has permission to New Single Family Home

AT 417 Island Ave, P.I. Call 090 0010001

CHECK-LIST AGAINST ZONING ORDINANCE #04-1757

RE: approx. 411-415 Island Avenue, Peaks Island – existing CBL: 090-0-010 & 011 – IR-2
Zone – application #04-1751

First Floor Plan

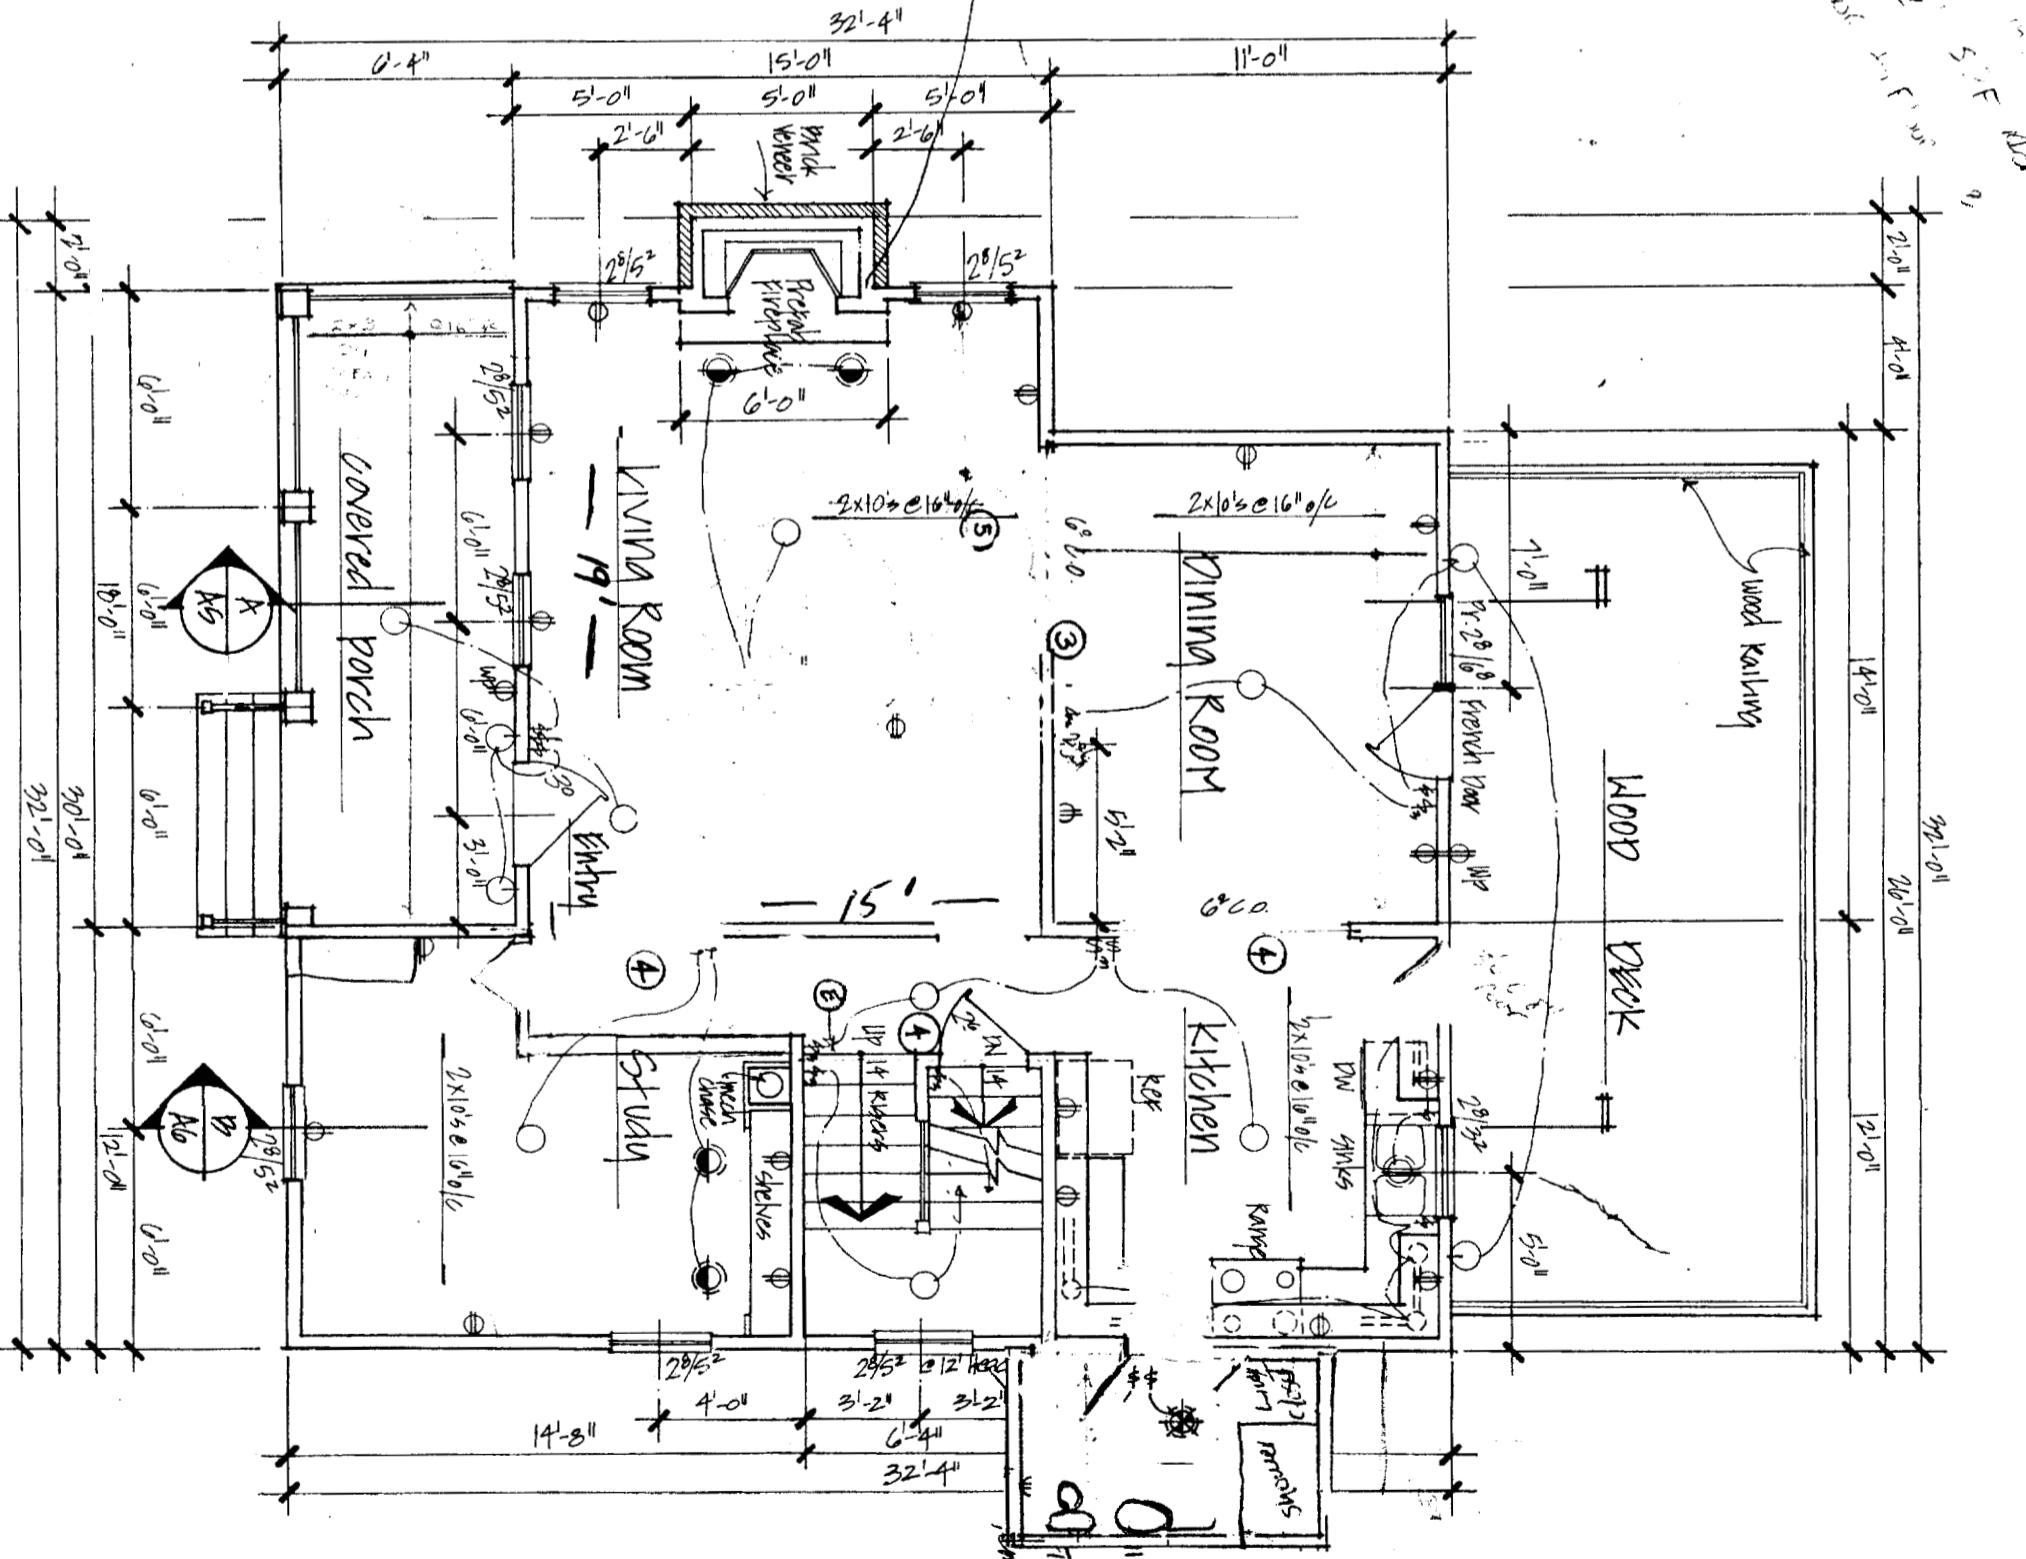
OK for revised plans dated 2/23/05
plans with bldg are not to scale
Bldg plans don't match site plan

It is also important that all plans are scaleable. All plans must match. Site plans shall reflect exactly what is shown on the building plans. Currently both sets of **plans** are different. It is also noted that the current building construction plans show a daylight basement in the rear. It is my understanding that there is to be no daylight basement. This makes you submitted building plans defective. It is important to submit plans that reflect exactly where and what you intend to building. Once a permit can be issued, our field inspectors will be checking to be sure that is being built is what was approved. If there are any changes to an approved permit, an amendment application is required to show those changes and to be approved *prior* to their implementation.

IR-2

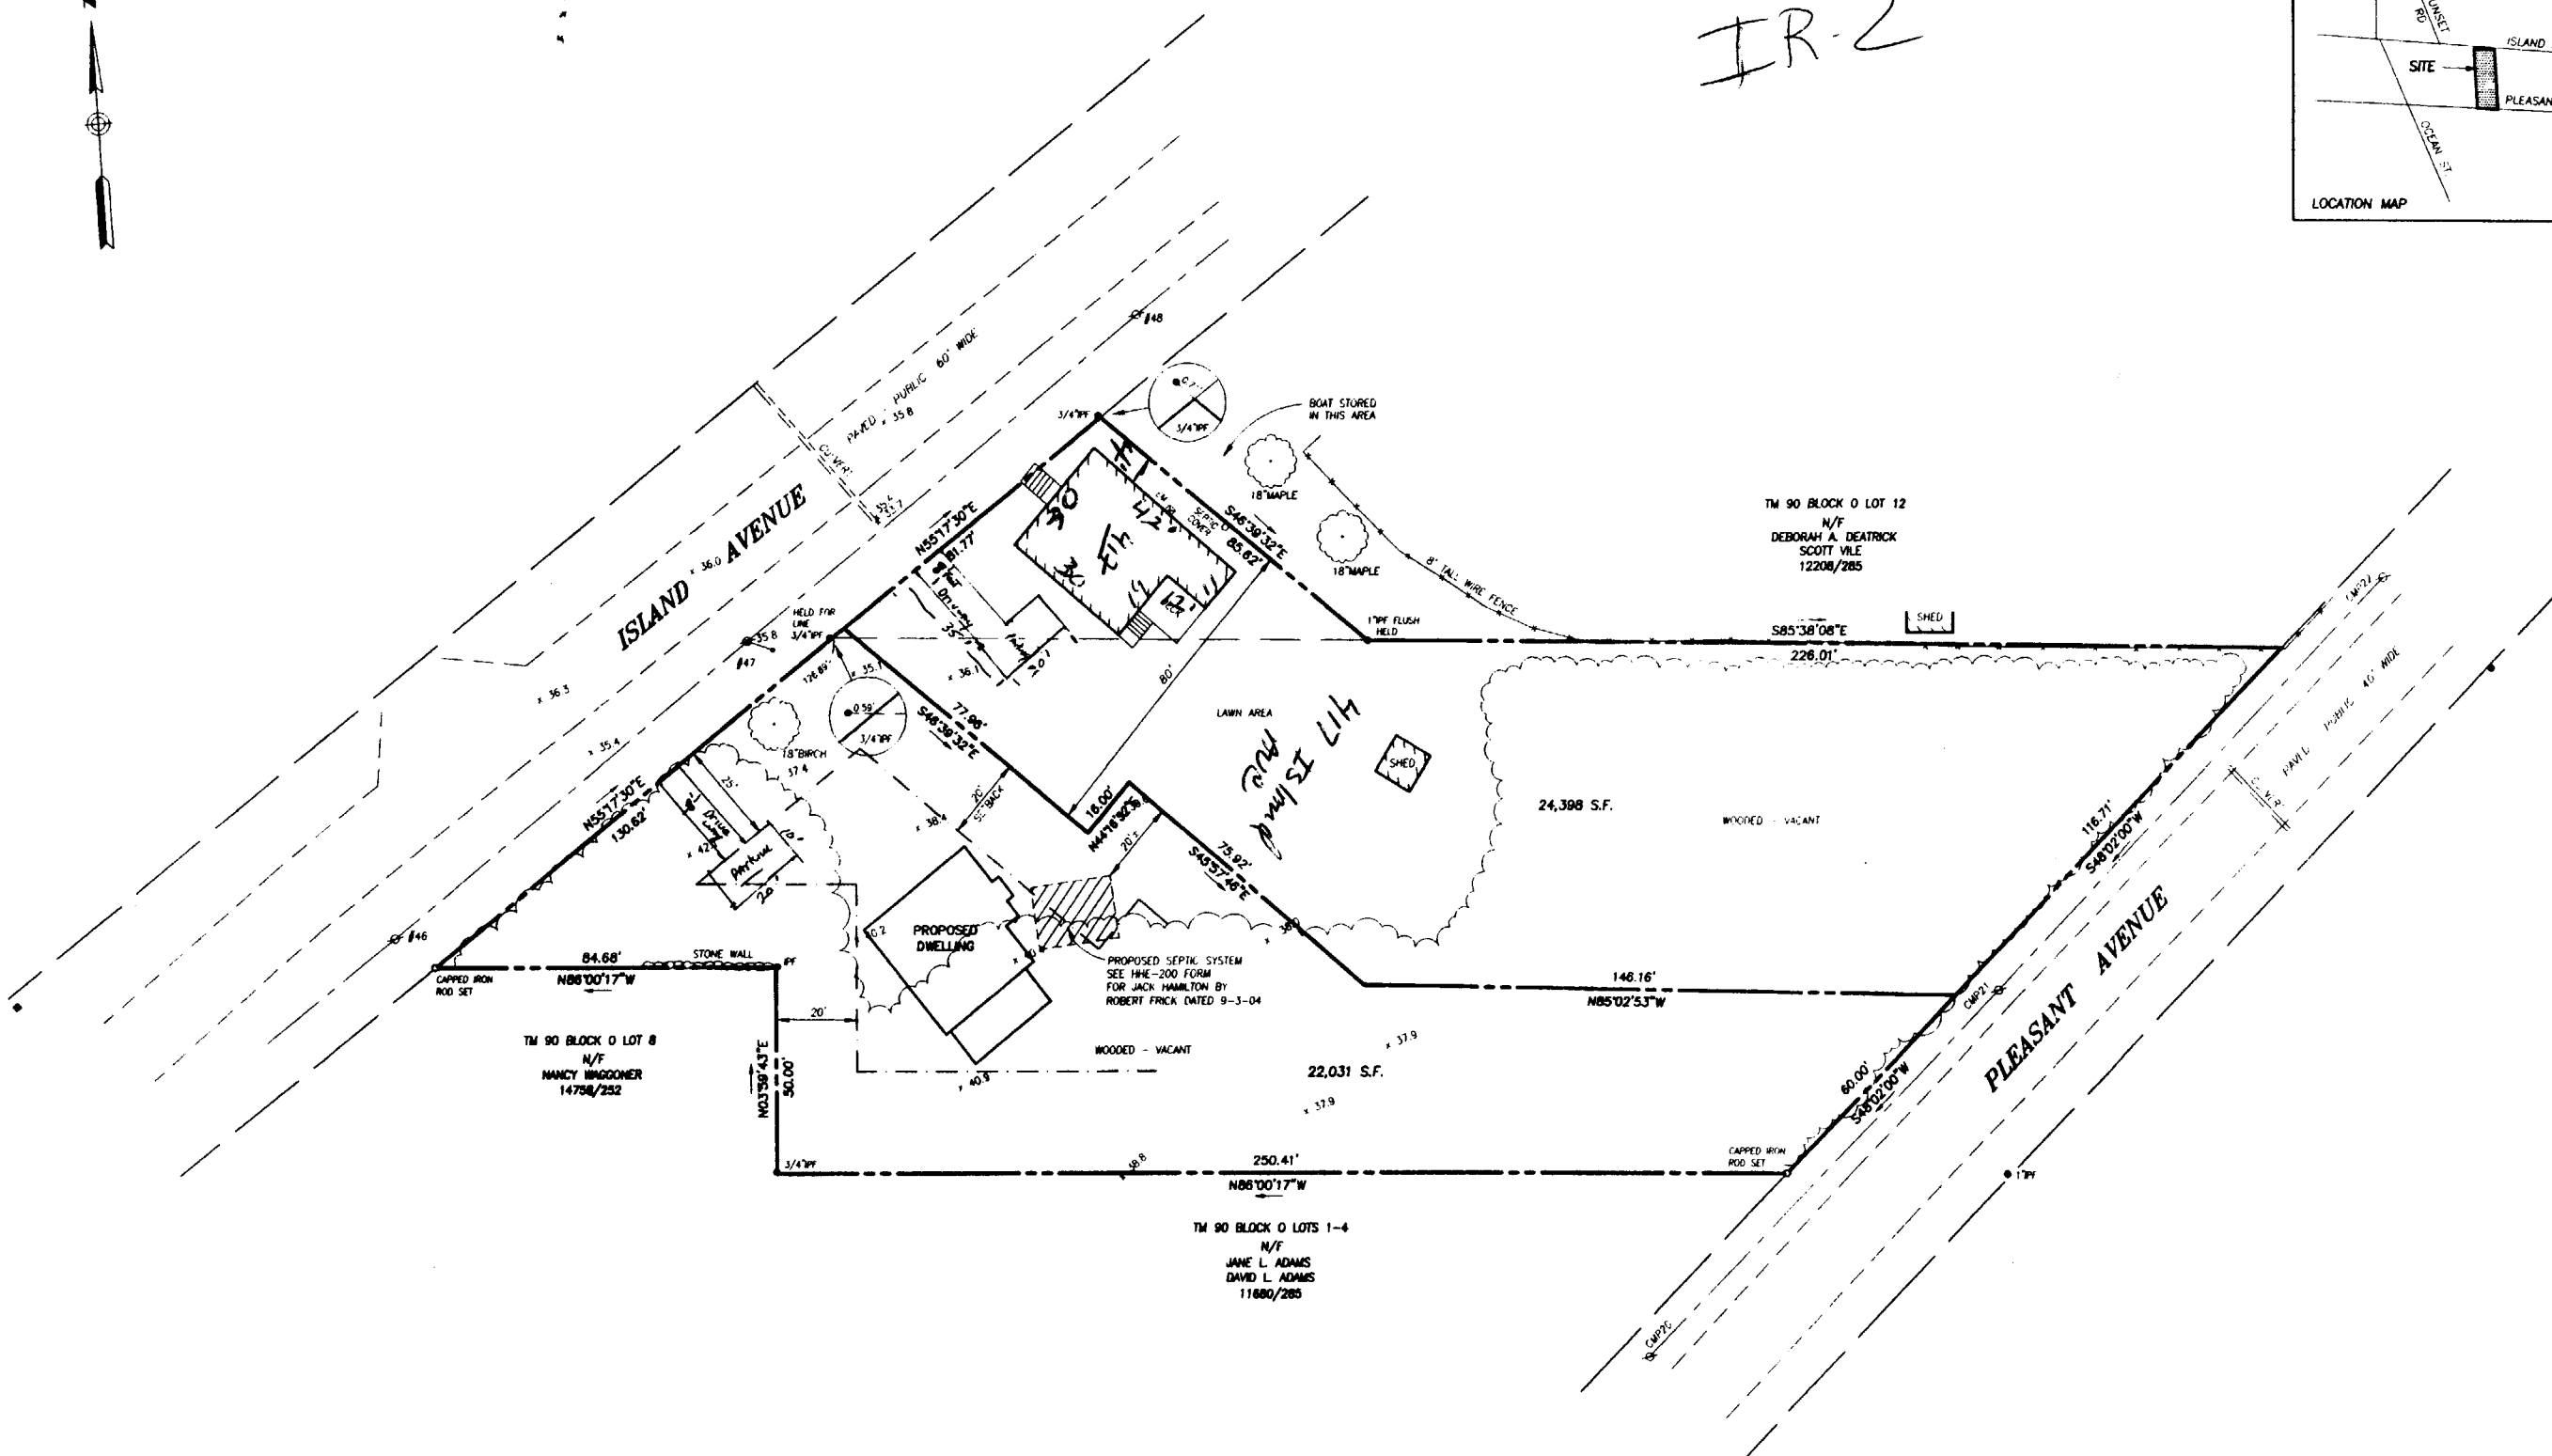
2/23/05 New plans brought in - only one parking space for the new house shown and the pre-dev. and post dev. grades are not being shown

Off-street Parking - 2 SPACES req ~~2/23/05 - 25 hours~~ only showing one space on New - needs 2

Section 14-336(a) states that all required parking shall not be located within the required front yard setback. The IR-2 zone requires a 25' minimum front setback or no less than the average depth of the buildings on either side of the lot. Your plans are not complete enough to determine that you may use the averaging provision. Currently you are showing that the two required parking spaces are located within 25 feet of the front property line. This office also will need to see that the existing house lot has at least one parking space properly located on that lot. Currently no parking space is denoted.

3/7/05 He has shown me 2 parking spaces for the new dwelling. It is not practical in use, so I put a condition on my approval

- 1) You have shown that you will be providing two parking spaces for the new single family. However, these spaces are not very practical for parking and maneuvering. There is a condition that these two parking spaces be reconfigures for more practical maneuvering and parking.
- 2) It is understood thru conversations with the owner that the pre-development and post- development grades will be the same. There will be no fill on this site.
- 3) This property shall remain a single family dwelling. Any change of use shall require a separate permit application for review and approval.
- 4) This permit is being approved on the basis of plans submitted. Any deviations shall require a separate approval before starting that work.
